F/16/24/RES

Land at Ford Airfield Ford

Approval of reserved matters following outline permission F/4/20/OUT for phase reserved matters 4 (south), for the erection of 357 No. residential dwellings plus associated roads, infrastructure, parking, landscaping, open space & play areas and associated works. This application affects a Public Right of Way, may affect the setting of a Listed Building and falls within CIL Zone 1

Recommendation: Further information required

Figure 9: Final Coloured Site Layout for Phase 4
Source: FINC Architects

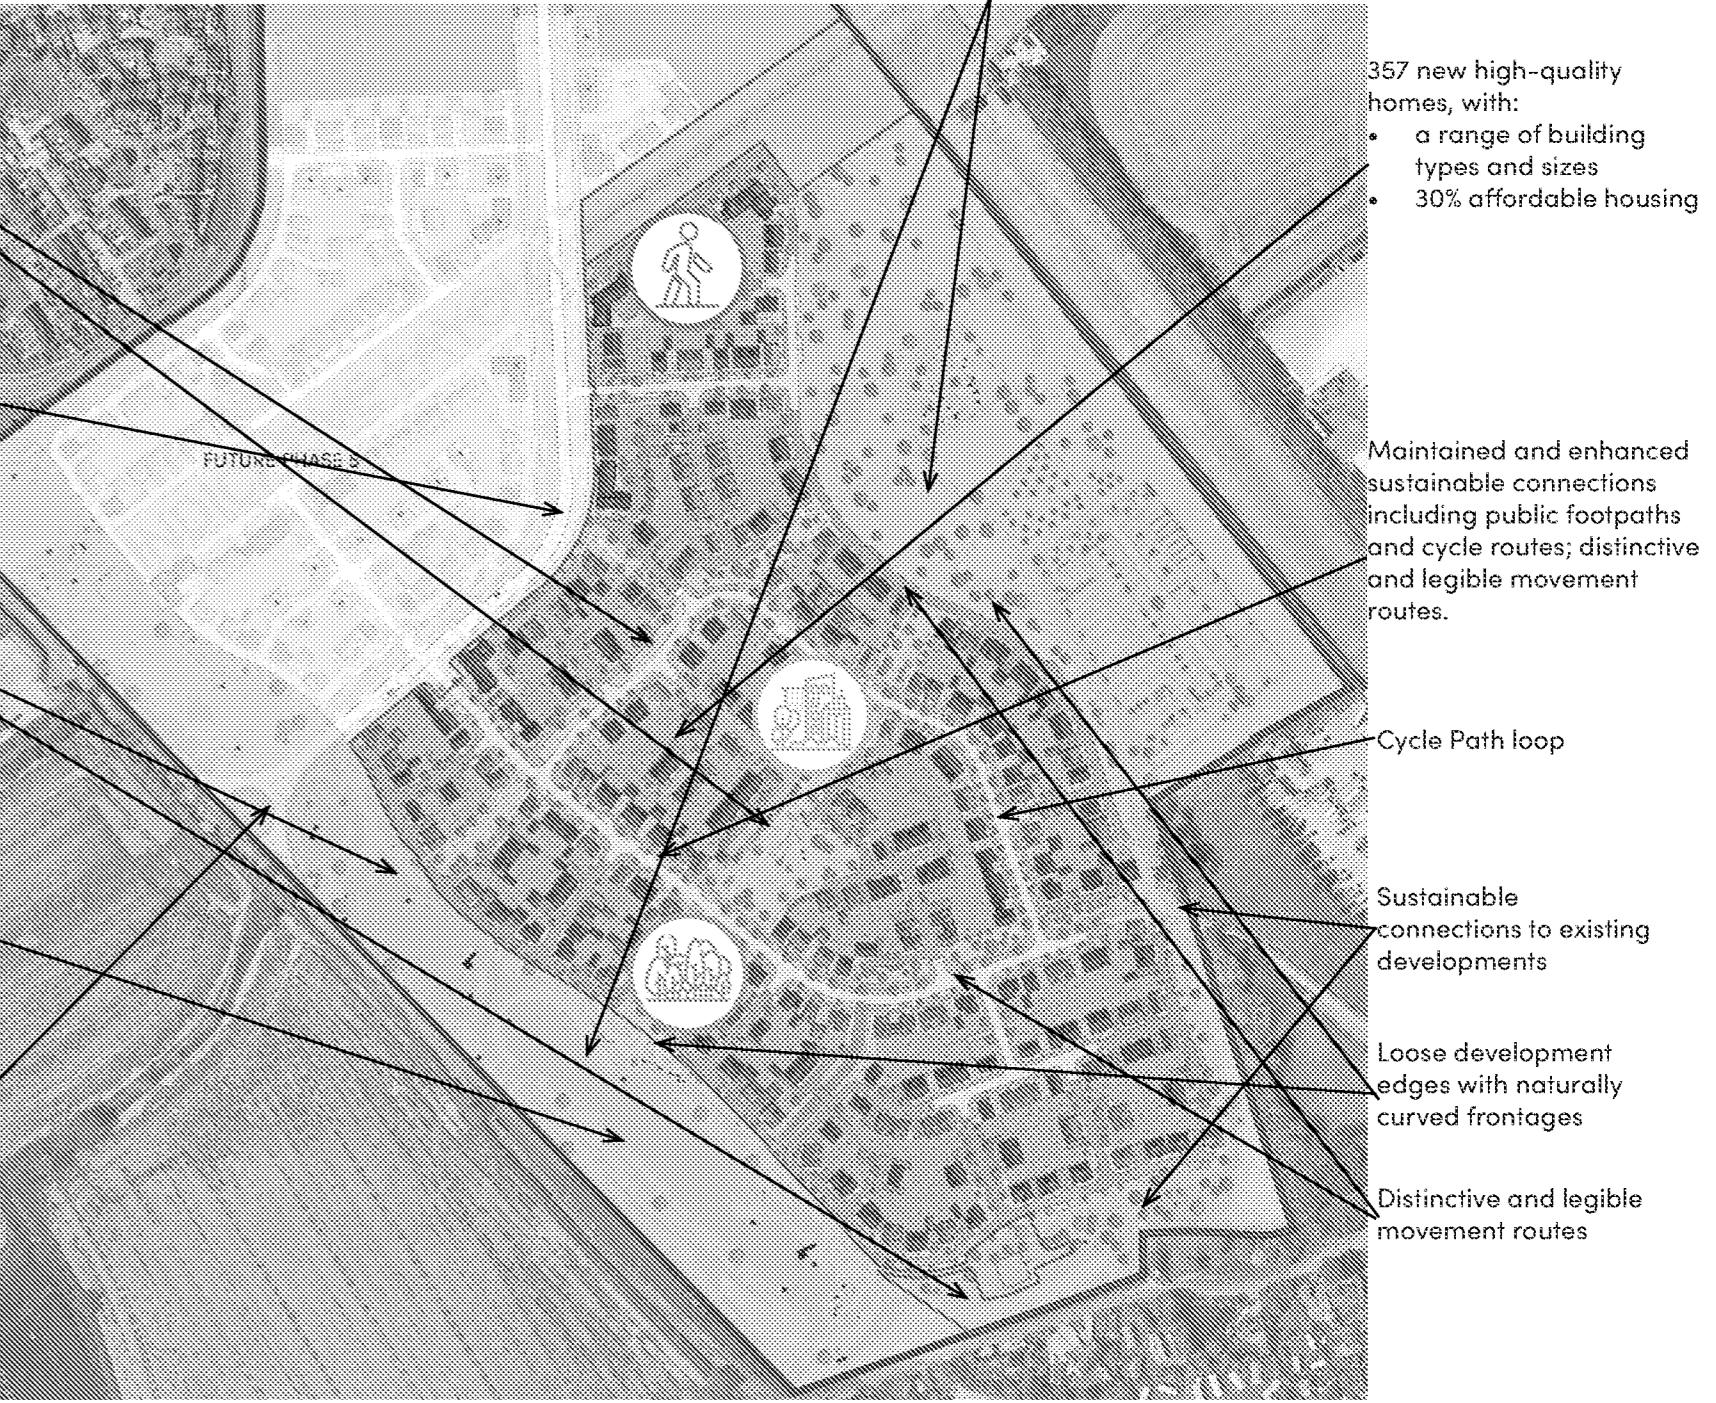
Whilst there is only a limited number of houses on the runway (and fronting onto the new runway corridor park), it is not fully clear how the designs can be considered to meet the design code reference of 'contemporary industrial'. It is not clear at this time how the line of houses relates and interacts with the runway and the new park which limits the assessment that can be undertaken at this time.

Further, it is not clear from looking at the plans whether the linear park which runs along the runway to the northern side of the spine road is actually included within the reserved matter application or not. The reason for querying this is that this area is identified by a red line on some of the plans, but it does not appear in the landscape masterplan.

The site layout identifies that the closest part of the site will remain as open space, which is positive, as this will create a buffer between the non-designated heritage assets and the new houses.

This part of the lane is somewhat semi-rural in character and the introduction of further planting within the site to supplement the exiting simple hedgerow is supported. However it is not clear what is meant by 'woodland structure planting'. Would this include further trees and shrubs etc, or is it just low level plants?

As with other areas of the site, I would be looking for the boundary to consist of planting of various types and heights including some trees, which would help to soften the impact of the development. This planting should be native species which are typical of the rural character of the locality. I also believe that the trees should also be more mature on planting for a more instant impact.
